Planning Application Reference No.: 3/2022/1129

Address of Development: Martholme Greenway

I write in objection to this Retrospective Planning Application 3/2022/1129 regarding the Land at the Old Track Bed, Bridge Heywood Caravan Park, Whalley Road, Read. i.e. The application is for retrospective change of use with minor engineering works and associated landscaping works for the reuse of the former railway embankment and track bed to form an informal recreational amenity area in association with the adjacent holiday park.

Earth bund and bench seating
Scale 1:200

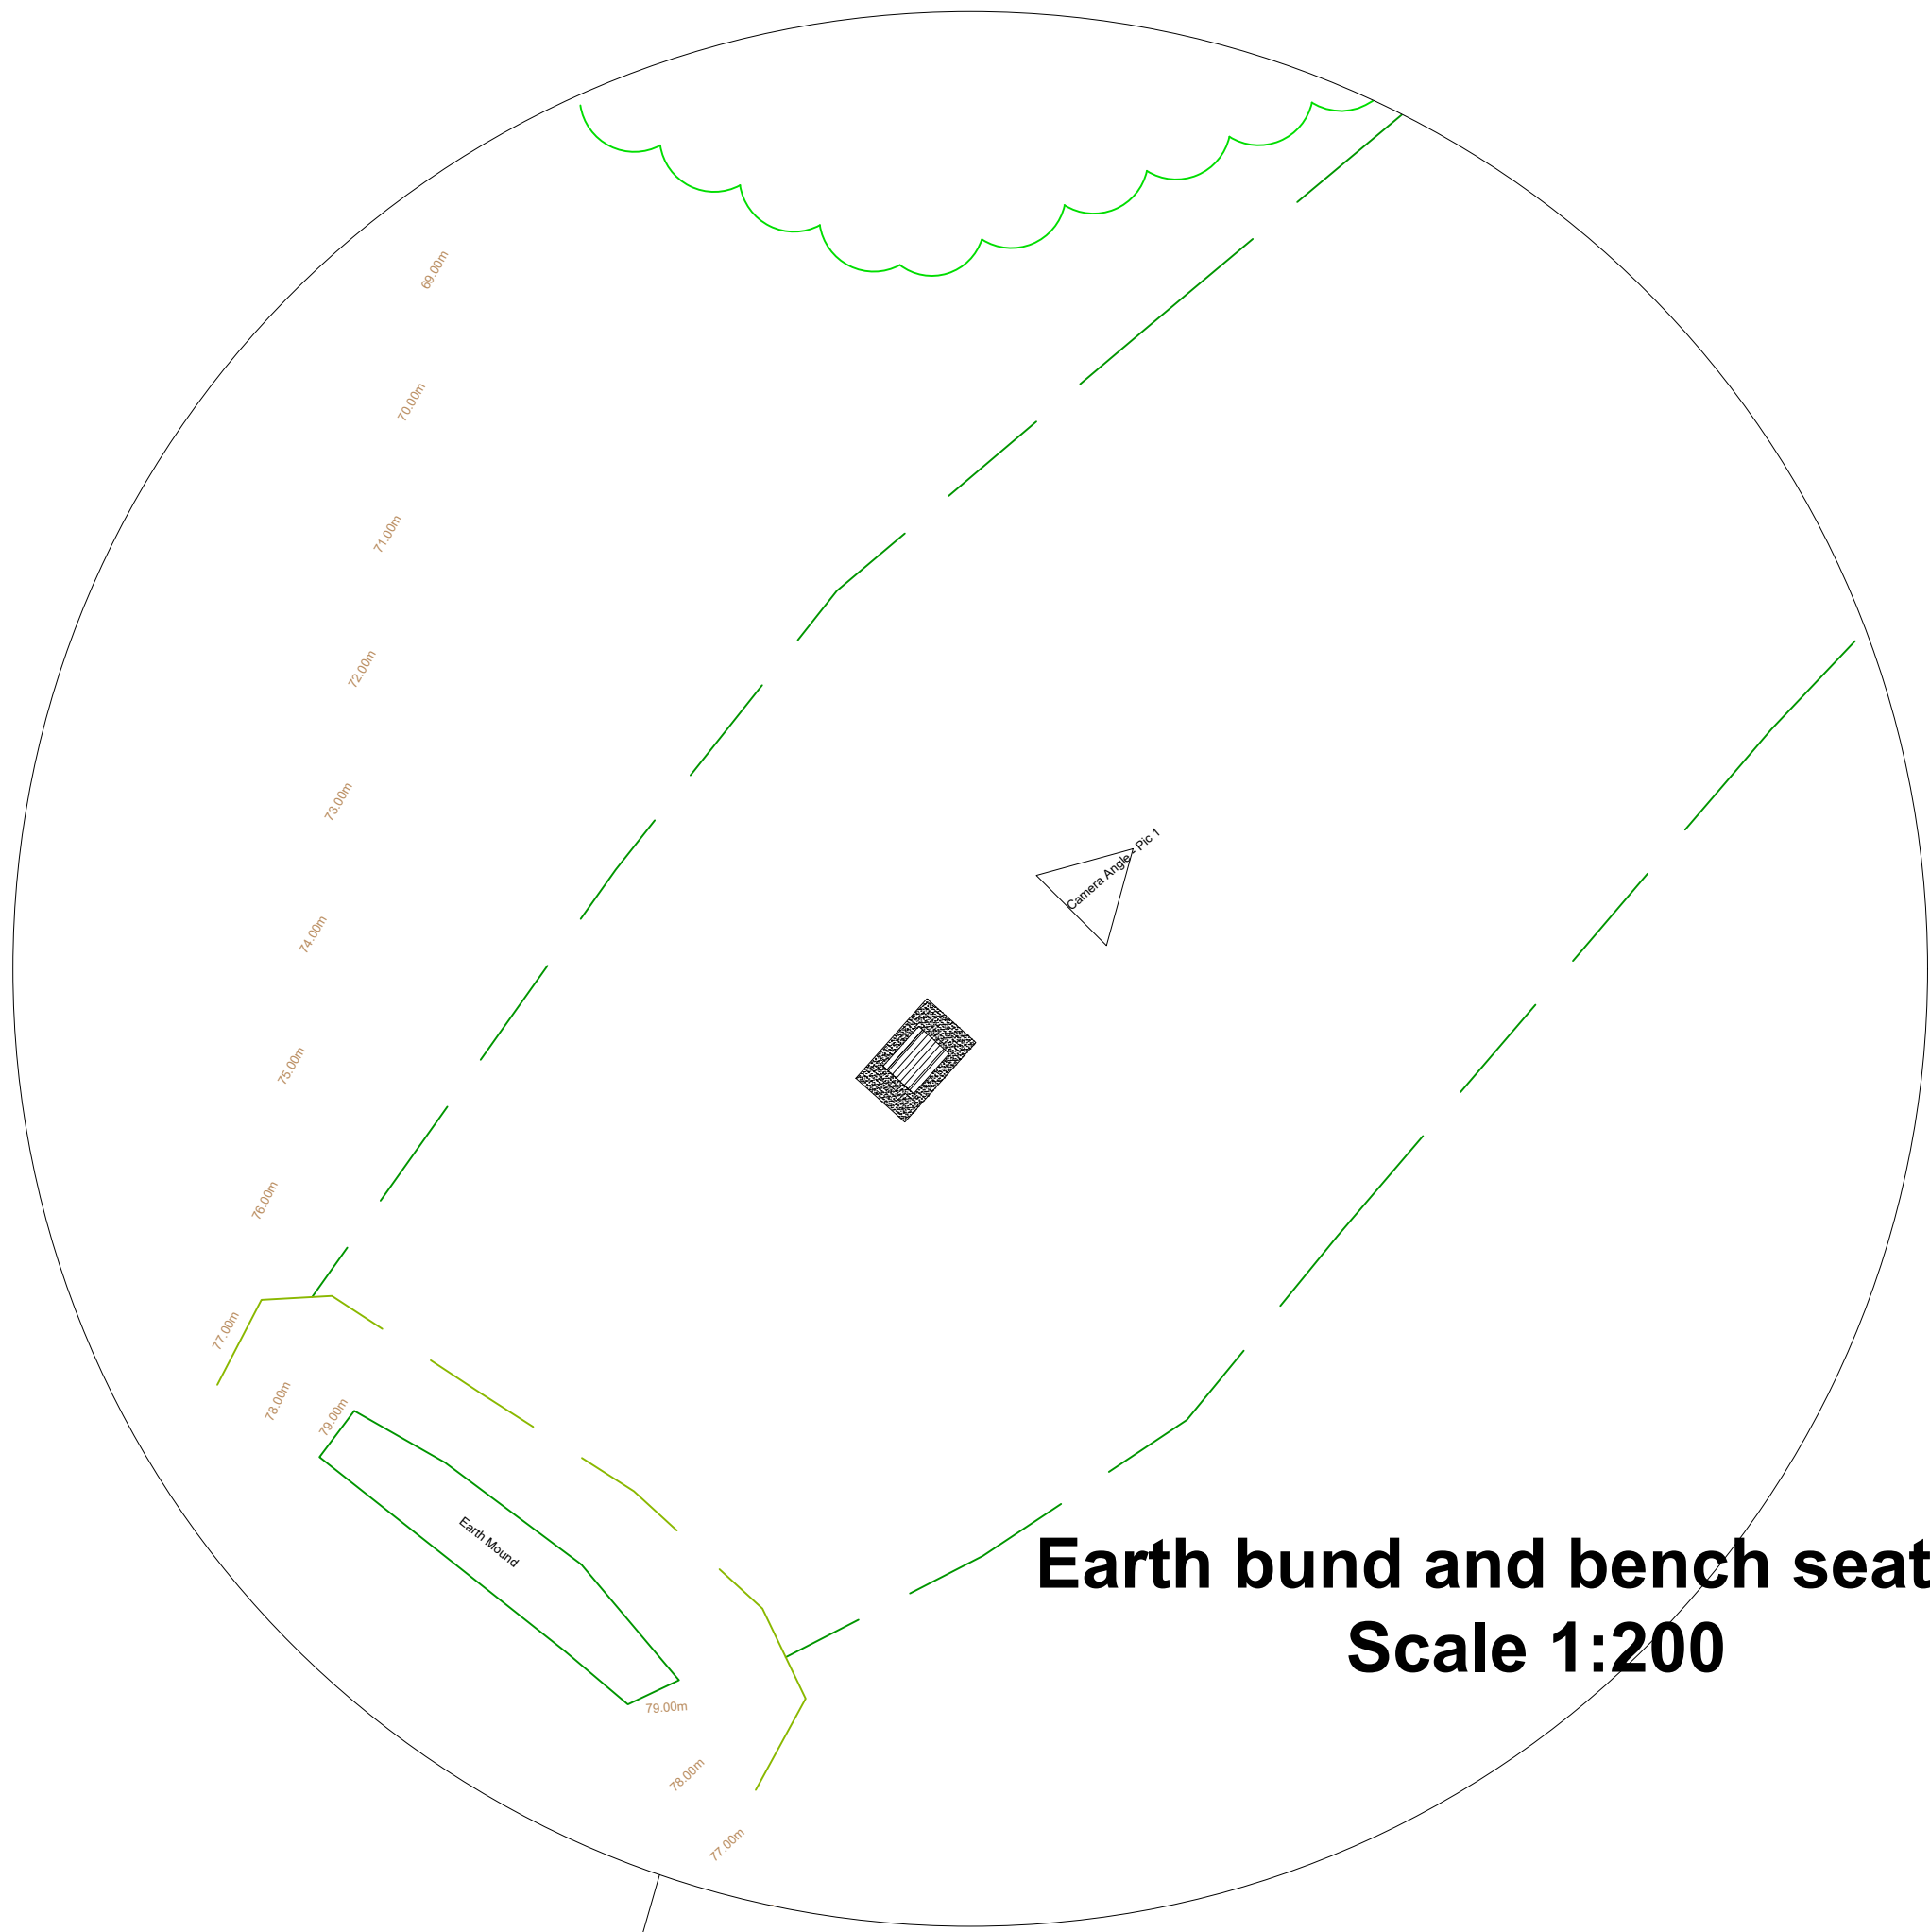
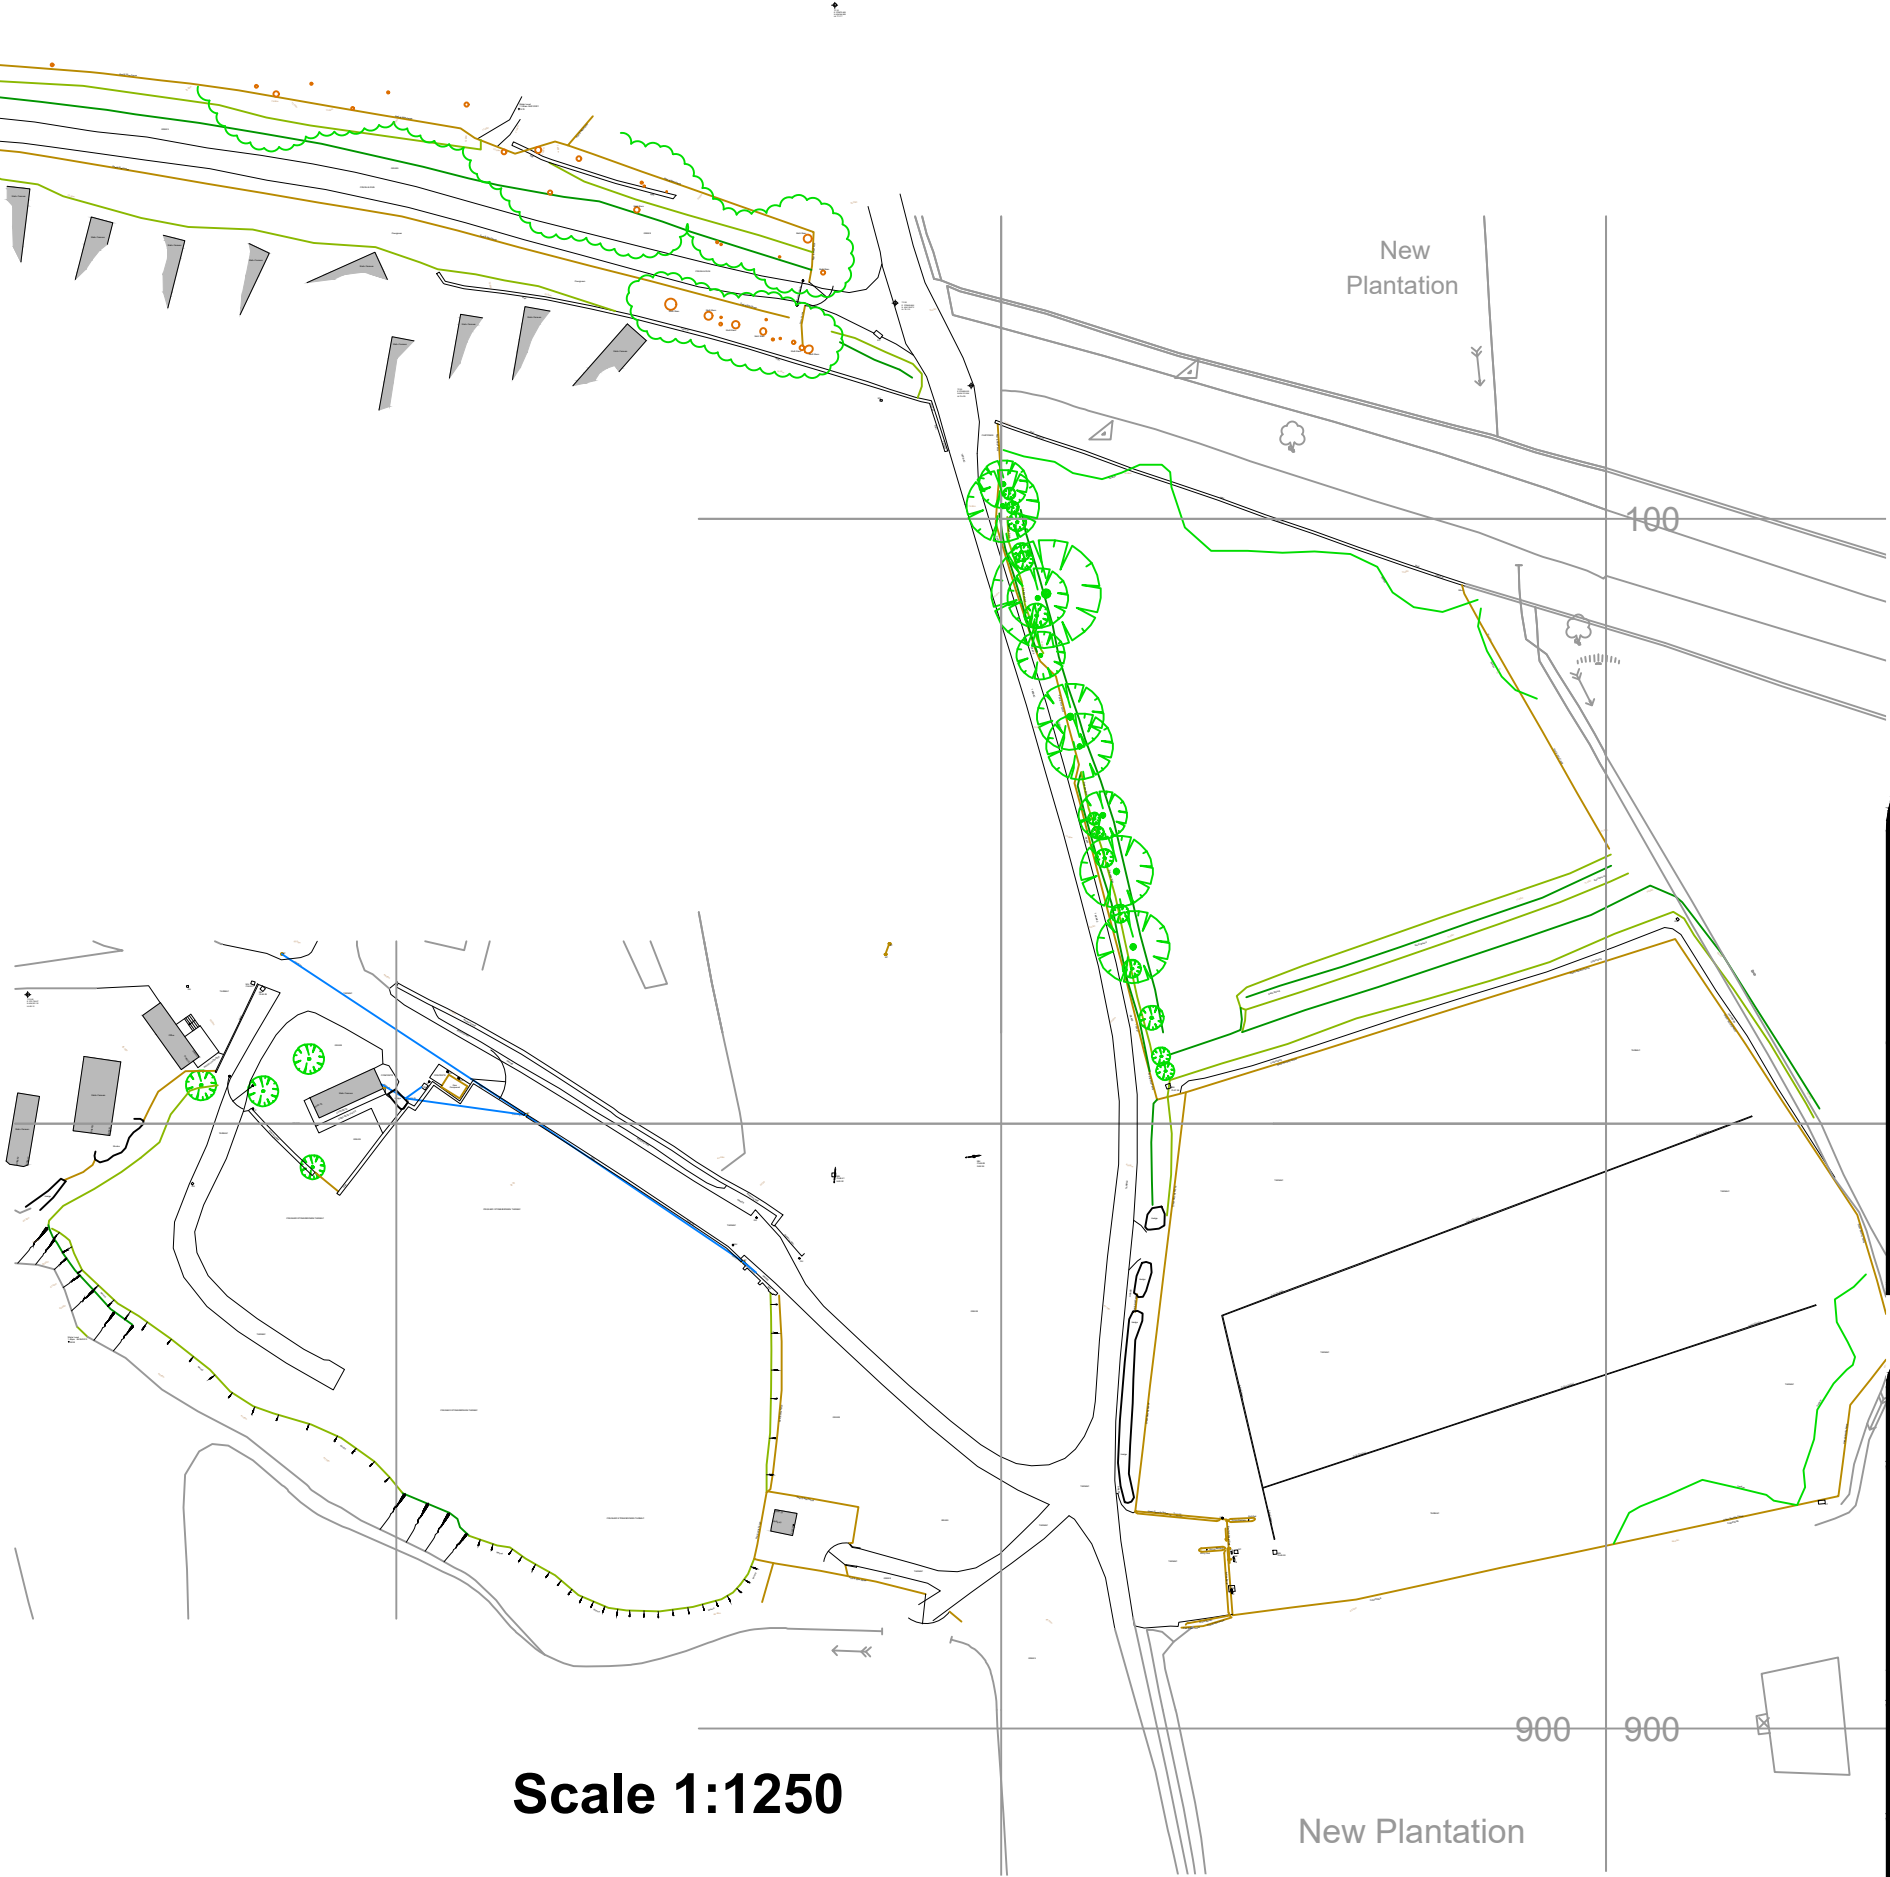
The dreadful Bund and Ditch bulldozed into position at the Read end of the Viaduct has both removed the supporting earth to the Viaduct itself, and has, as importantly, made the passage of Badgers now impossible. The prescriptive hole left to allow the Badgers to move from one side of the Viaduct land to the other side, when the fence was first raised, was blocked by the landowner before this destructive work started.

The Landowner states that this Bund and Ditch has been constructed to prevent trespass by non residents of his Caravan Park onto his land. There was, and still is, a 2meter high Metal Fence with spikes along the top to prevent this...and this together with substancial drops of 4/5 meters each side of the viaduct wall...is surely enough to prevent the worry of Trespass without the construction of this eyesore.

Hardcore now forms the level top to form a "Sterile" pathway which also houses picnic benches.....one can only describe it as a "Stone desert"..infertile and lifeless. It will take years for this eyesore to blend into our once beautiful, unspoilt landscape.
